From: Thomas Callaway
Sent: 23 June 2015 15:53
To: Planning.Responses
Subject: RE: Planning Consultation on A/67/15/DOC

APPLICATION NO: A/67/15/DOC

Registered: 19-MAY-15
Site Address: Former Pound Nursery Roundstone Lane Angmering BN16 4AL

Description of Works: Application for approval of matters reserved by condition imposed under A/167/14/PL relating to conditions 3, 4, 6, 10, 11, 12, 13, 14, 15, 18, 20, 21, 22 & 23 for schedule of materials, tree protection, prevention of surface water drainage on highway, construction of roads, footways/casual parking areas, Travel Plan, archaeological programme, ecological mitigation report, broadband speed, foul water sewerage disposal, surface water drainage, SUDs system, refuse & recycling bins & decentralised & renewable or low carbon energy source.

CLIENT	Barratt David Wilson Southampton				
PROJECT	Pound Nursery Roundstone Lane, Angmering				
TITLE	Site Layout Proposed Drainage Sheet 1 of 1				
DRAWN	A Davies	DATE	Dec 2014	PROJECT NO	22411
ENGINEER	G Waller	CHECKED		DWG NO	1221
SCALE	1:250 @ A1, 1:500 @ A3			REV	G

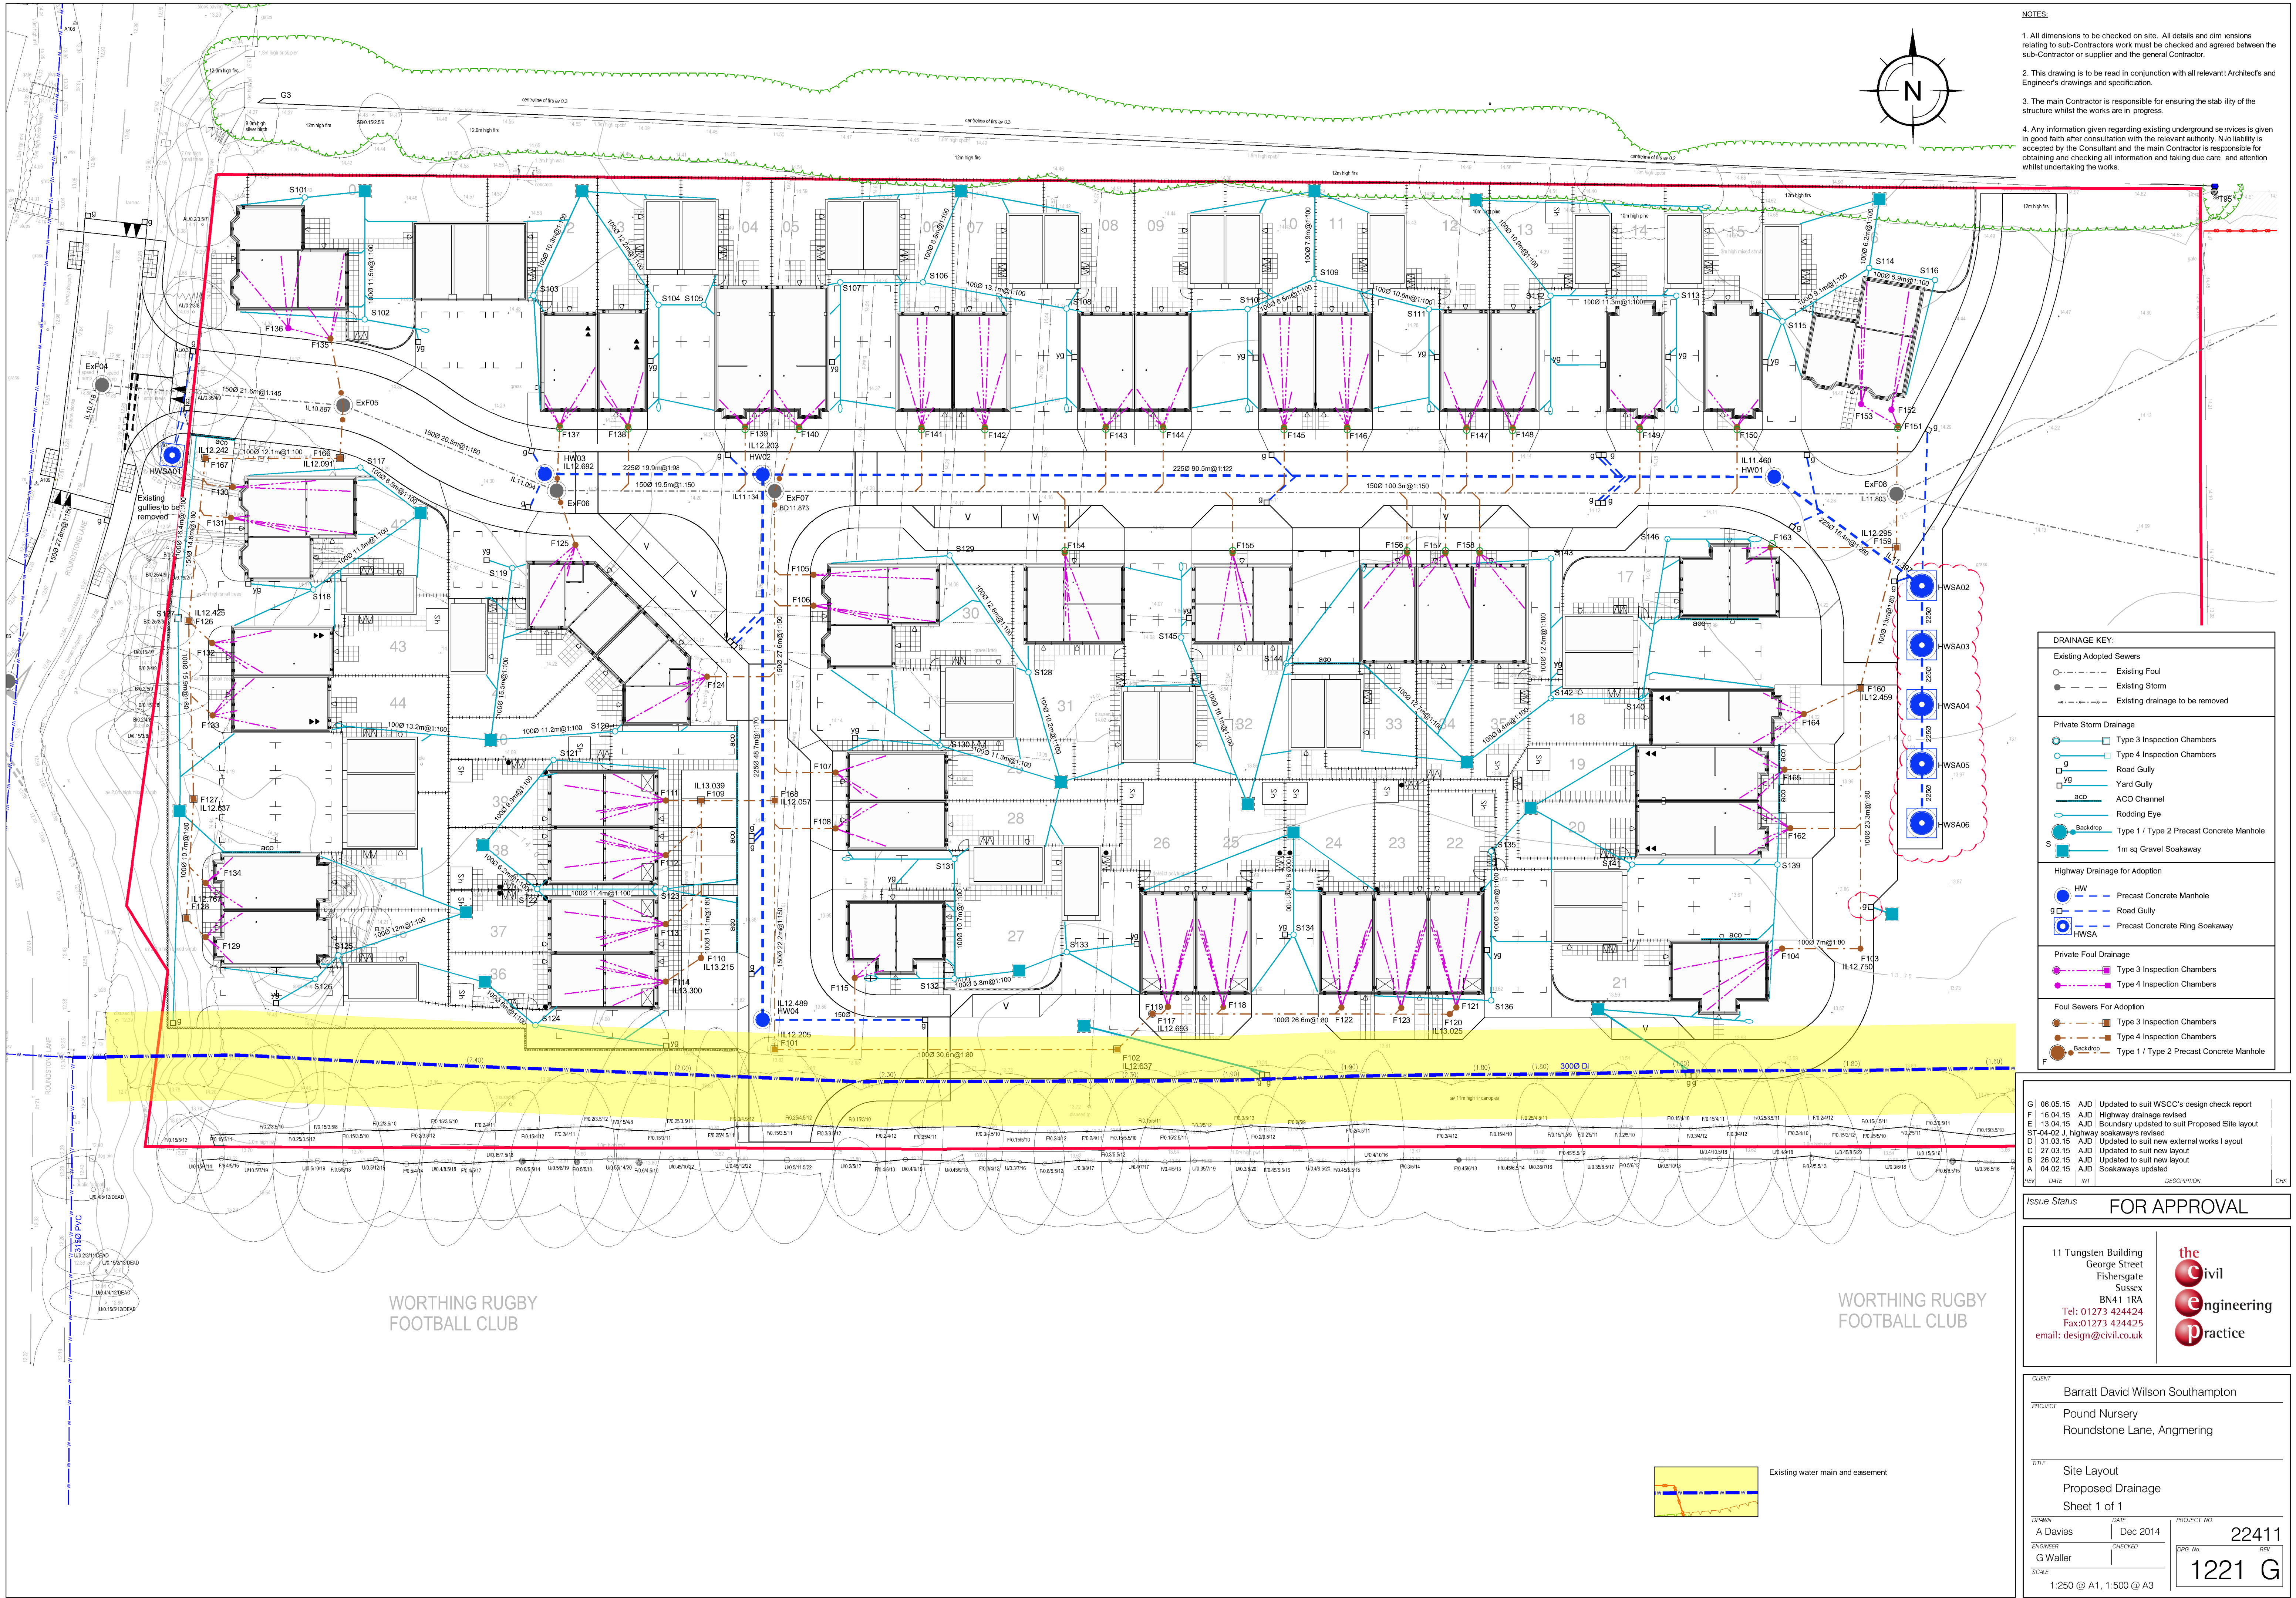
Should the applicant be intending to use the same site characteristics as for Swanbourne Park (i.e. ground type, infiltration rates etc) that will be fine, I have agreed this in principle with Mark Akmenkalns who is looking at the adoptable highway drainage.

We are still missing a finished construction drawing for the private soakaways as also proposed on the Swanbourne Park site. We were making some headway with the consultant on this but I am yet to receive an acceptable finished drawing. Also typical calculations for the soakaways during the 1 in 100 year storm event plus 30% are required for this site and Swanbourne Park (identical examples may be used but we haven't received anything yet).

Highway drainage is to be approved by Mark Akmenkalns at WSCC, calculations and construction drawings will probably be required.
